City of Portland, Maine - Building or Use Permit Application
 389 Congress Street, 04101 Tel: (207) 874-8703, Fax: (207) 874-8716

Permit No: 08-0334	Issue Date:	CBL: 132 I008001
------------------------------	--------------------	----------------------------

Location of Construction: 3 MATTHEWS ST	Owner Name: LITTLEFIELD FARM LLC	Owner Address: 153 ANDOVER ST	Phone:
Business Name:	Contractor Name: Nial Construction	Contractor Address: 191 State Road Suite #2 Kittery	Phone 2077520091
Lessee/Buyer's Name	Phone:	Permit Type: Duplex	Zone:

Past Use: Vacant Land - See Permit# 080324	Proposed Use: 2 Family - New 2 Family Home on existing foundation	Permit Fee: \$1,615.00	Cost of Work: \$151,700.00	CEO District: 5
Proposed Project Description: New 2 Family Home on existing foundation		FIRE DEPT: <input type="checkbox"/> Approved <input type="checkbox"/> Denied	INSPECTION: Use Group: Type	
		Signature:	Signature:	
PEDESTRIAN ACTIVITIES DISTRICT (P.A.D.)				
Action <input type="checkbox"/> Approved <input type="checkbox"/> Approved w/Condition <input type="checkbox"/> Denied				
		Signature:	Date:

PORCH DETAILS

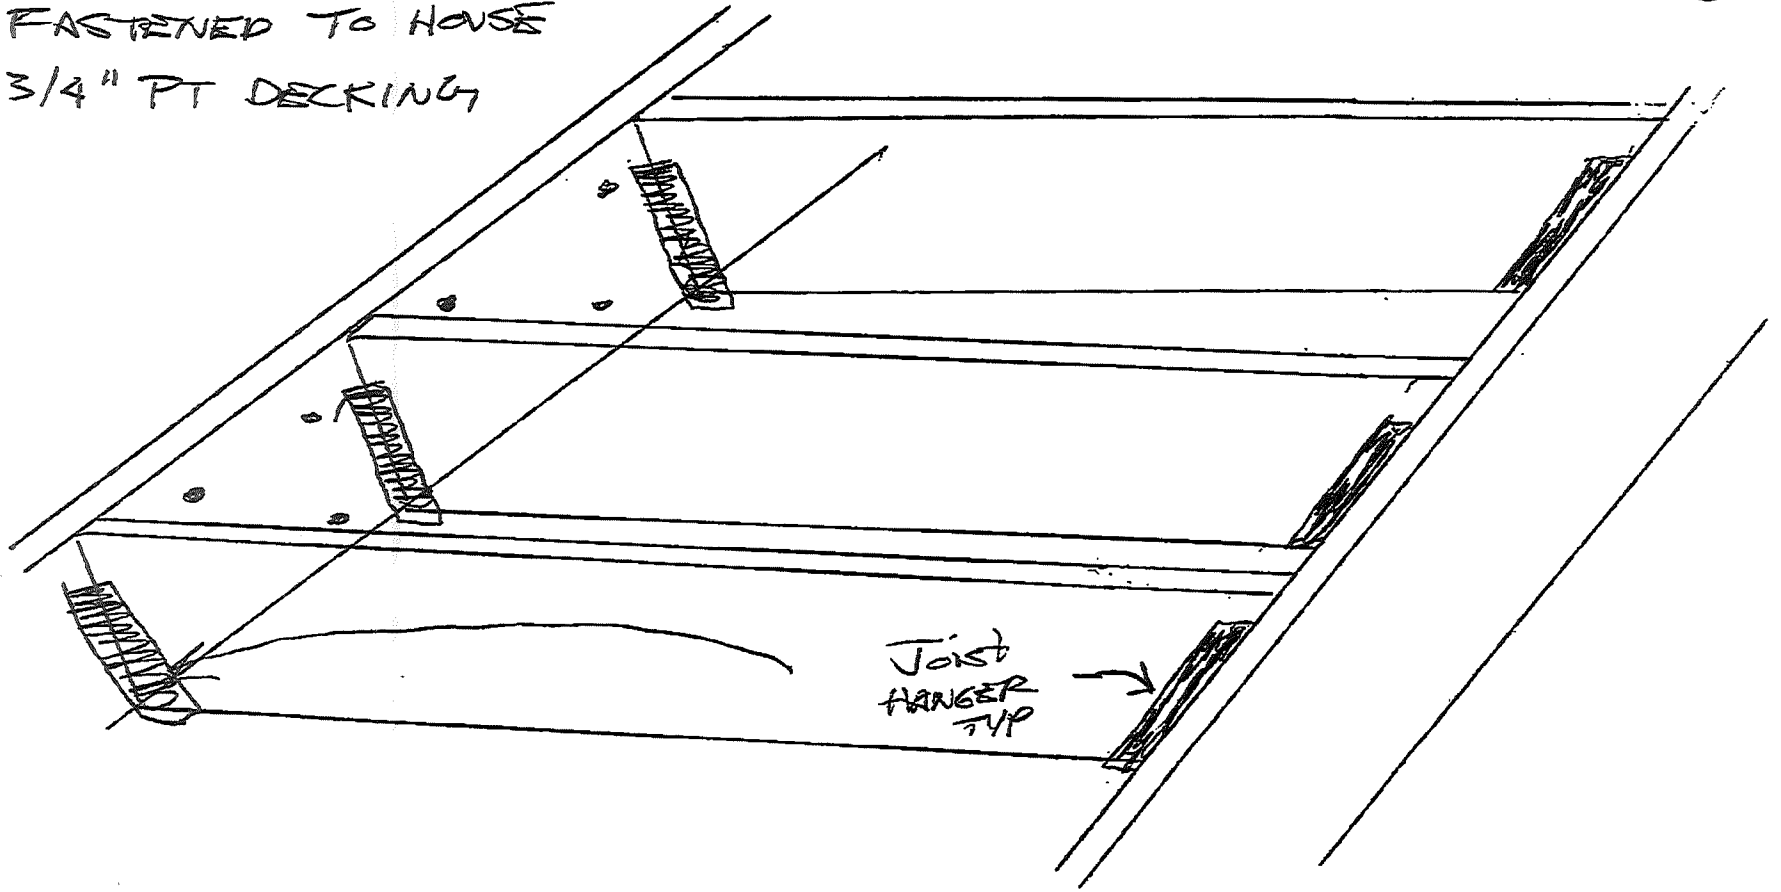
- 1) The reconstruction of the rear decks must be approved under a separate permit.
- 2) All floors and walls that separate dwelling units or dwelling units and common areas are required to meet a 1 hour fire rated assembly and sound transmission rating of 45 STC.

RIGHT ELEVATION

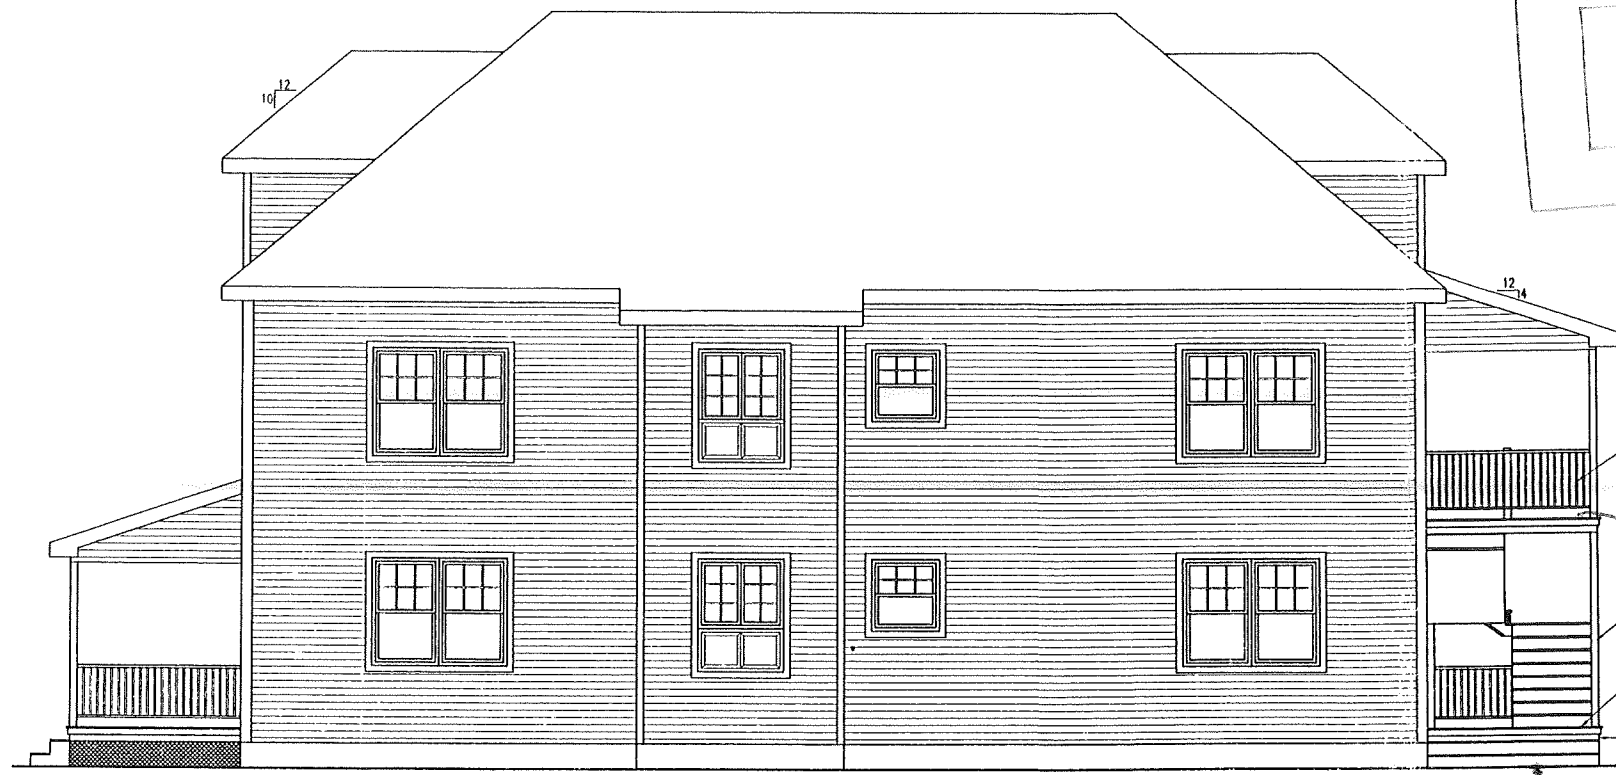
5/5/2008-amachado: Received new plans for building. Proposed dormer is bigger than existing. Need to check the pitch with Tammy.

5/6/2008-amachado: The front & rear dormers are a little wider, but OK under section 14-436(a). The pitch of the roof is shown as 10/12 which fits what was there originally. Talked to Larry Sturdivant. Need full size plans for revised elevation and third floor. Also the rebuilt front and rear porches need to match the size of the existing conditions on the plot plan. Larry said to note that on the plans. Also, according to Larry the original deck and stairs that wrapped around the side from the rear porches is being removed. The first floor porch will just have steps to grade off the side.

REAR ELEVATION

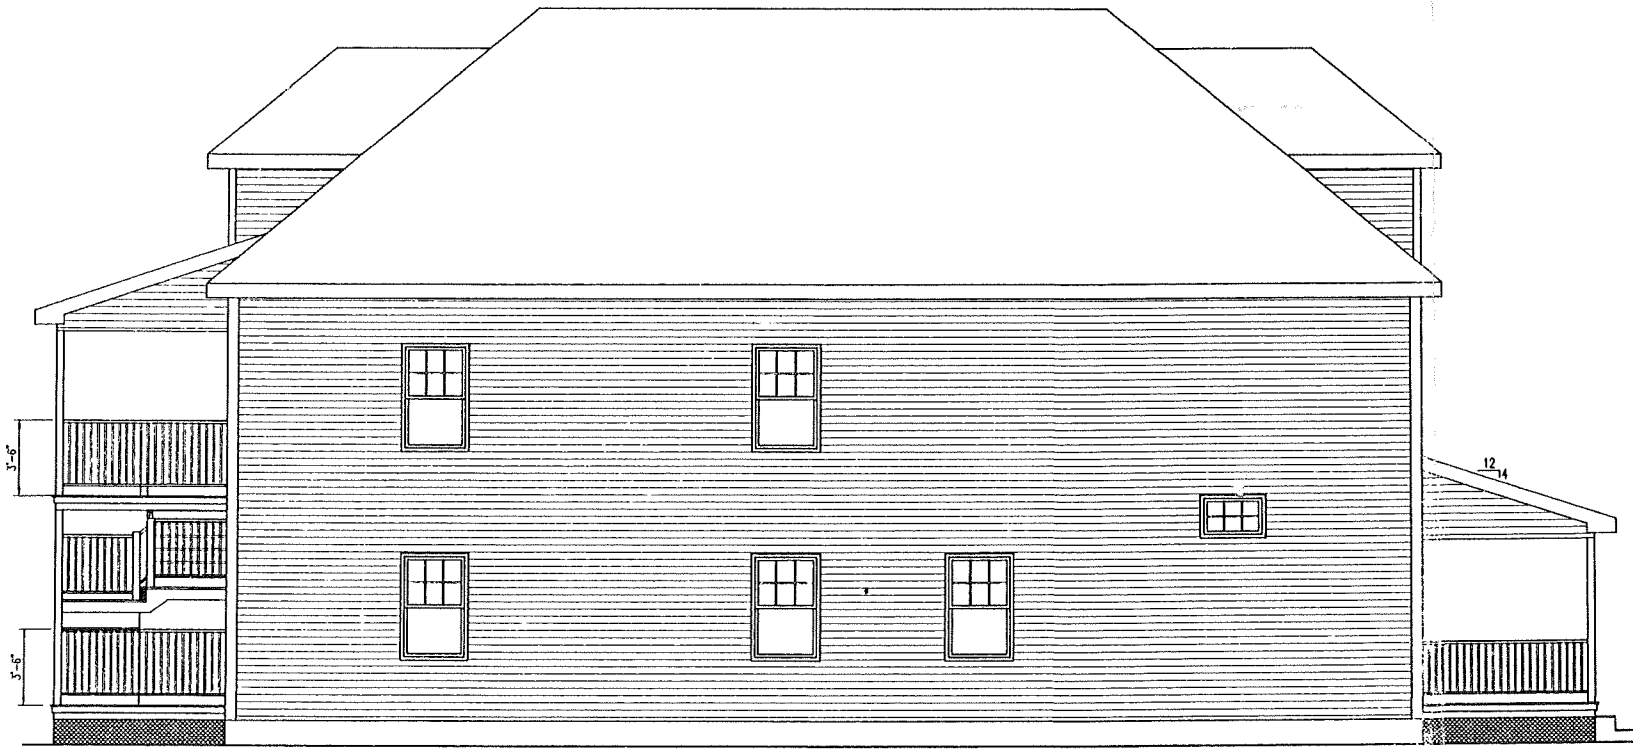
Note: The front and back porches must be rebuilt in the original footprint. They may not go any closer to the property lines. **Ok to Issue:**

SECOND FLOOR PLAN

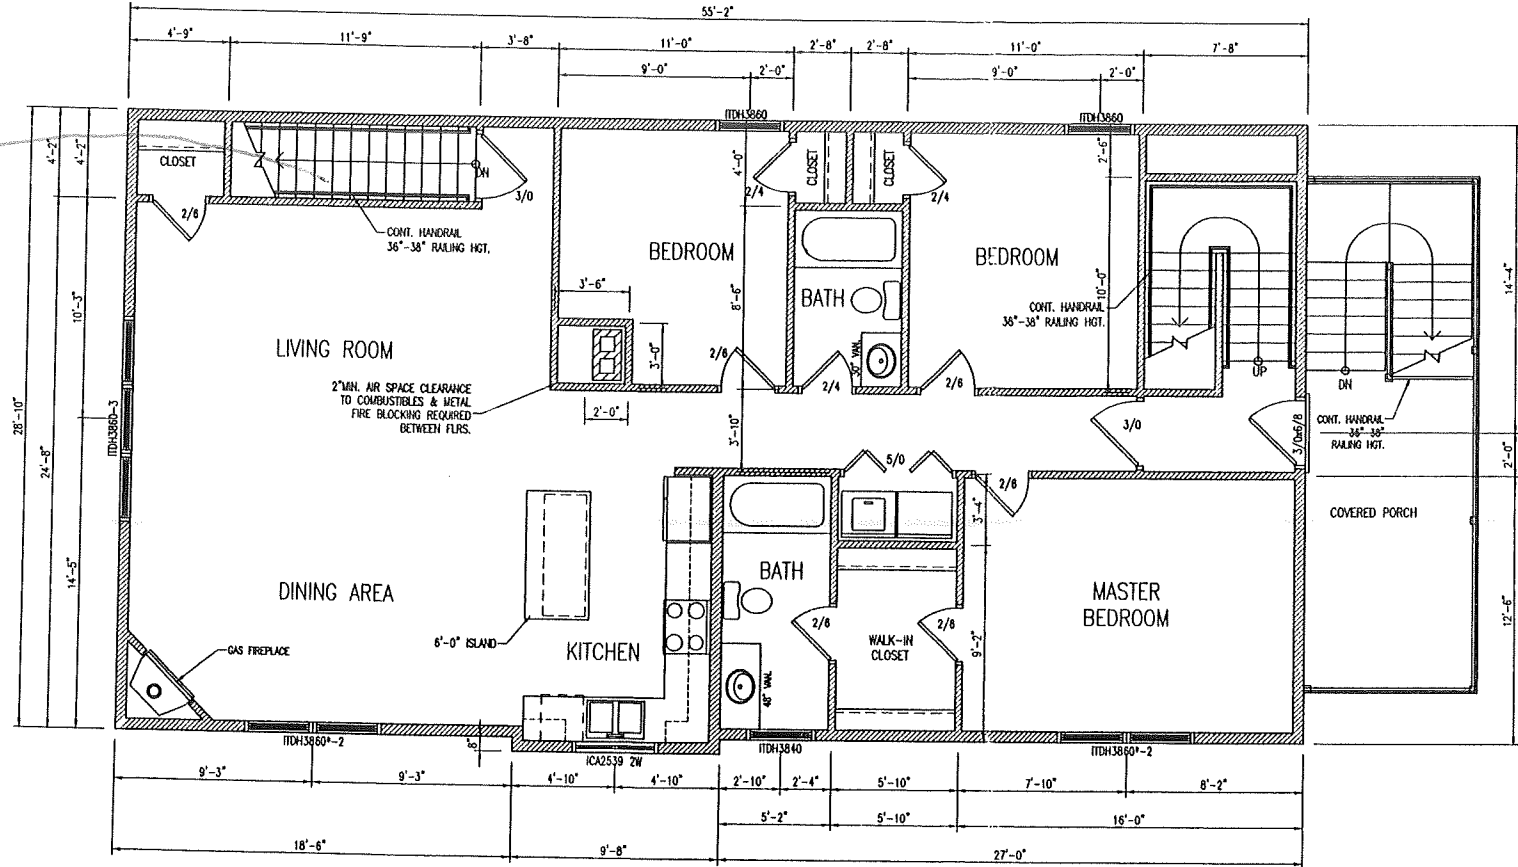
- 4) The basement is NOT approved as habitable space. A code compliant 2nd means of egress must be installed in order to change the use of this space.
- 5) Hardwired interconnected battery backup smoke detectors shall be installed in all bedrooms, protecting the bedrooms, and on every level.
